REVIEW OF GLENDELL CONTINUED OPERATIONS PROJECT MINE PLAN AND MINE PLAN OPTIONS

OCTOBER 2020

REPORT TO:	Matthew Sprott Director Resource Assessments NSW Department of Planning, Industry & Environment 320 Pitt Street Sydney NSW 2000
REPORT ON:	Review of Glendell Continued Operations Project Mine Plan and Mine Plan Options
DATE OF ISSUE:	28 October 2020
MINECRAFT PROJECT NO:	K2006
AUTHOR:	J Jamieson – FAusIMM, ARMIT (Mining)
CONTACT:	8 / 12 Endeavour Boulevard North Lakes QLD 4509 Telephone: (07) 3482 3664 Web: minecraft.com.au Email: mcc@minecraft.com.au

Figure 7: Preferred Mine Plan and Mine Plan Options

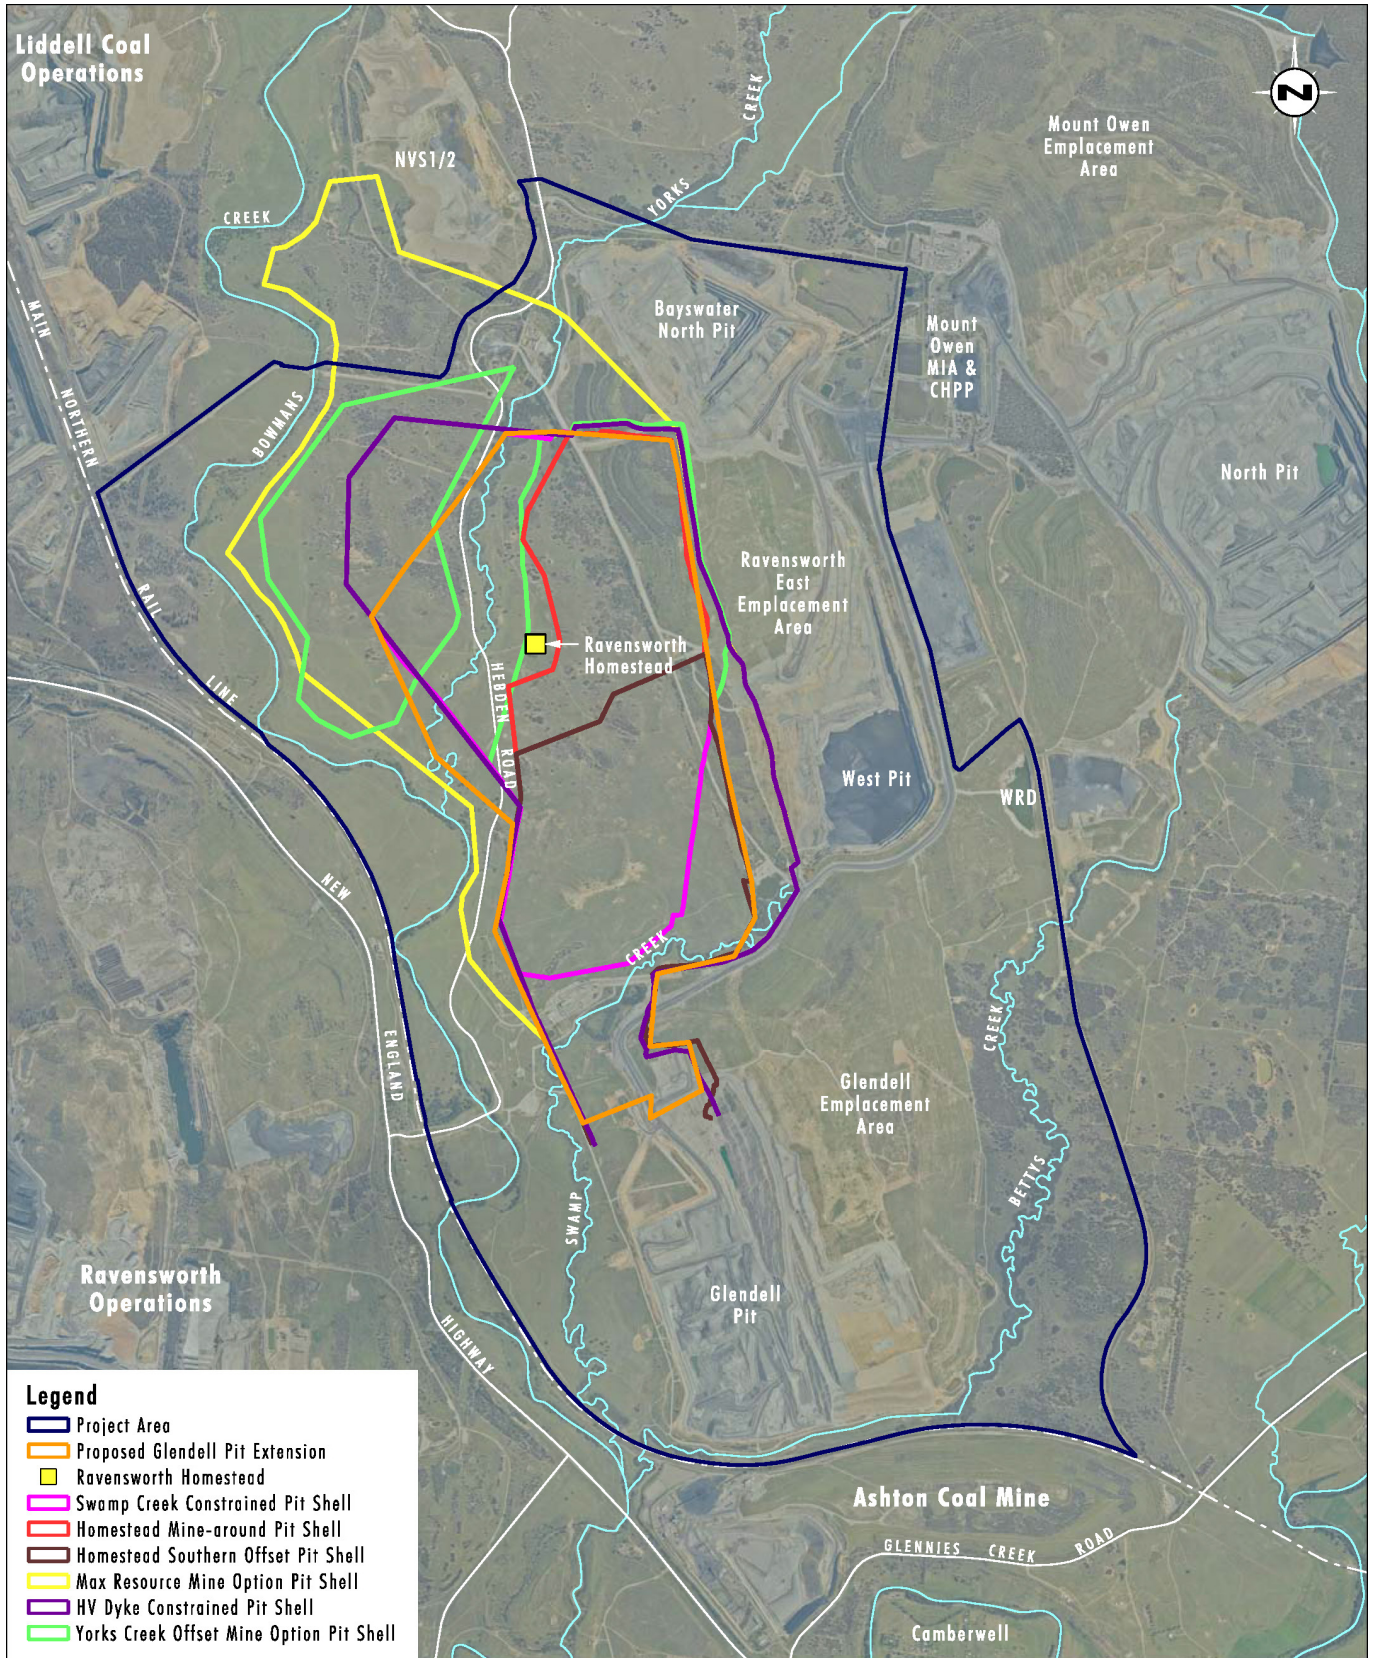
In Figure 2.1 the footprint of Option 3 along its Eastern Boundary is shown as more to the East than the PMP footprint

the reason for this is that further drilling and information was gained that caused the later PMP design to be tightened or the PMP pit narrowed inward.
